RESPONSE TO SUBMISSIONS  
RESOURCE RECOVERY FACILITY  
SSD 5339  
CONCRETE RECYCLERS PTY LTD  
7 MONTORE ROAD  
MINTO

13 September 2021

Figure 1: Site Plan

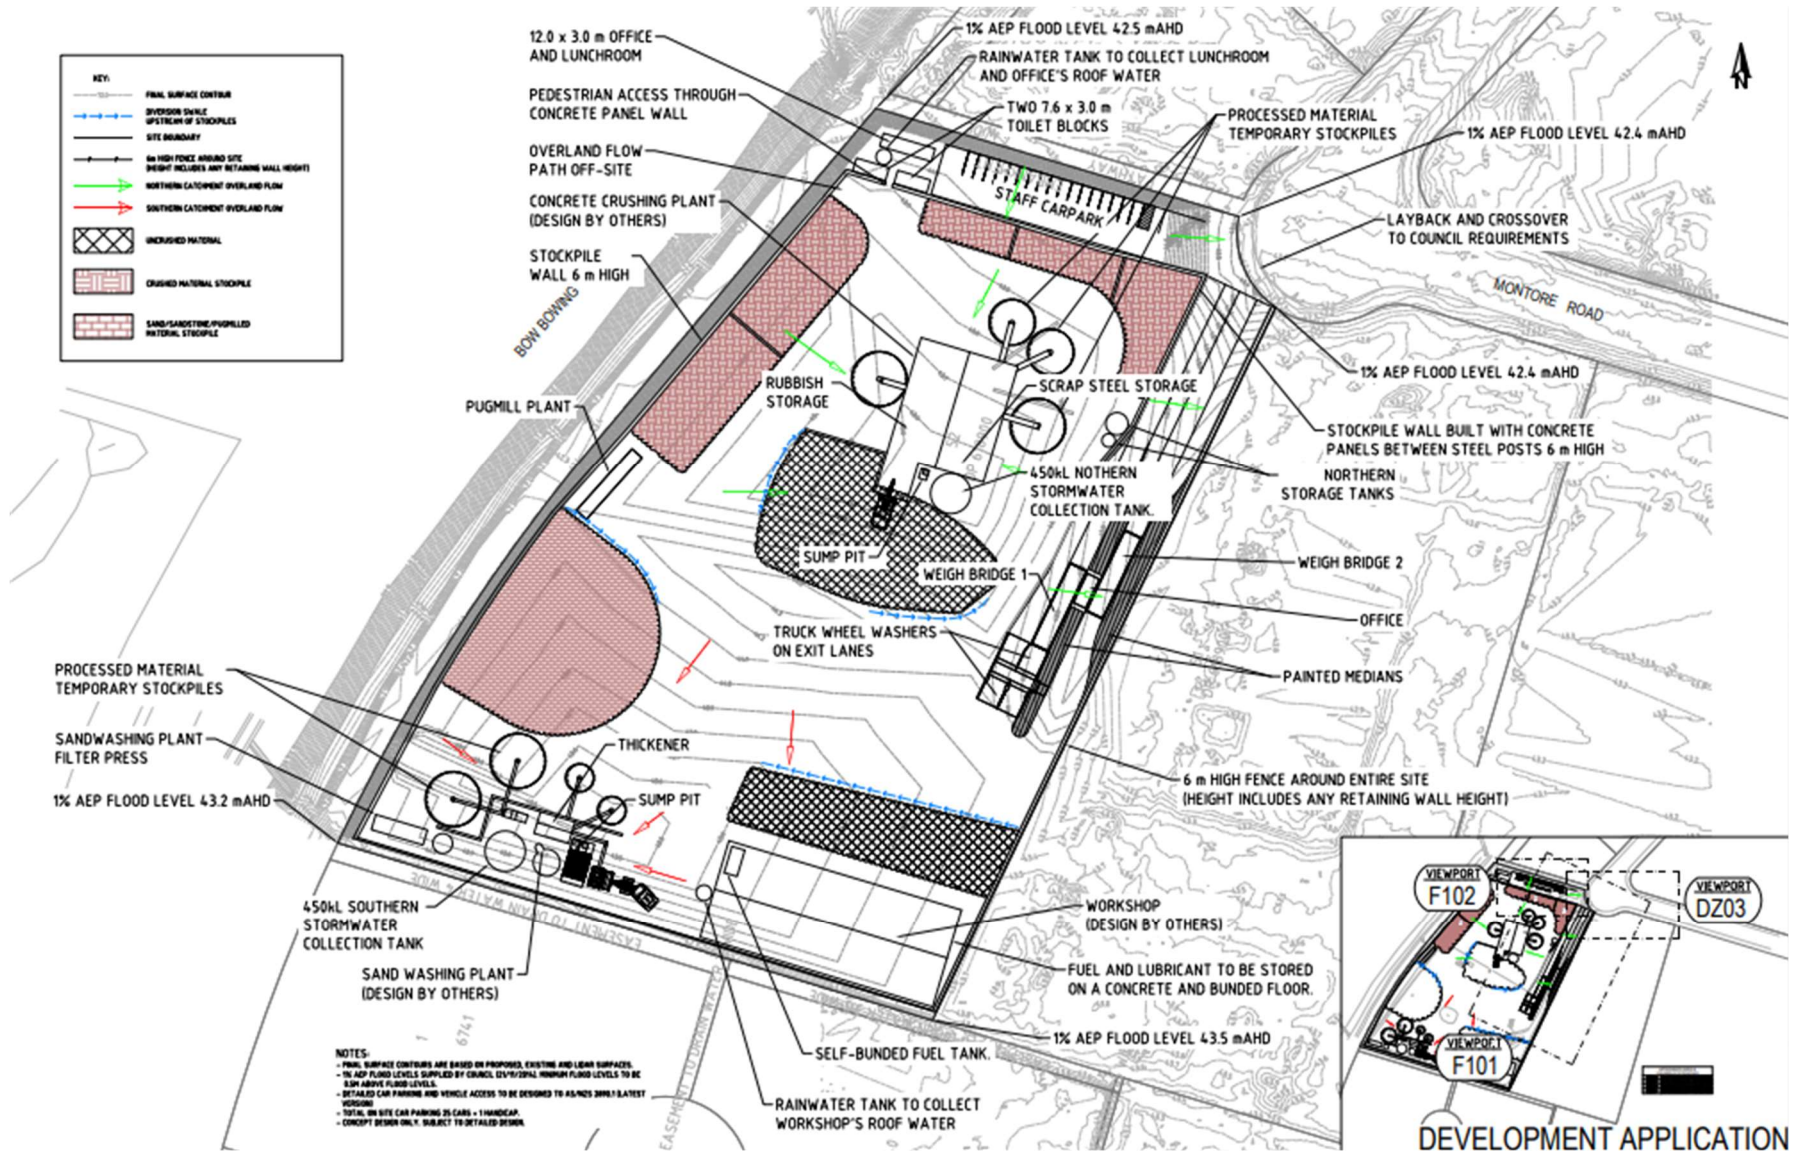
- *The Site Plan identifies numerous external waste and product stockpiles, please describe the stockpile management measures that would be implemented to ensure wastes are managed appropriately including maintaining their separation distances and heights.*
- *Please provide the size and volume of the individual stockpiles.*
- *The EIS explains that there would be some residual waste generated by the facility, and this waste would either be disposed of or sent for further processing. It is recognised that the metal waste storage area has been shown on the Site Plan, however, please also show where other wastes would be stored and explain how often they'd be taken offsite.*
- *The site plan shows one large stockpile for sand/sandstone and pugmilled material, please describe how this stockpile would operate to avoid the mixing of different products.*

The waste received is, after inspection in accordance with the EPA Guidelines, stockpiled in the following groups as shown on the Site plan:

Stockpile separation distances are not a requirement in the facility and stockpiles will touch each other. Stockpile heights will be controlled by visual height makers on walls/fences and buildings.

Stockpiles are shown on the Plan PS02-A401 A and are the approximate sizes and volumes shown below:

<b>Stockpile A</b>	60m long, 20m wide, 8m high with volume 8,000 tonnes
<b>Stockpile B</b>	50m long, 40m wide, 8m high with volume 20,000 tonnes
<b>Stockpile C</b>	60m long, 40m wide, 8m high with volume 25,000 tonnes
<b>Stockpile D</b>	70m long, 15m wide, 8m high with volume 12,000 tonnes
<b>Stockpile E</b>	60m long, 10m wide, 6m high with volume 5,000 tonnes
<b>Stockpile F</b>	25m long, 10m wide, 6m high with volume 2,000 tonnes.
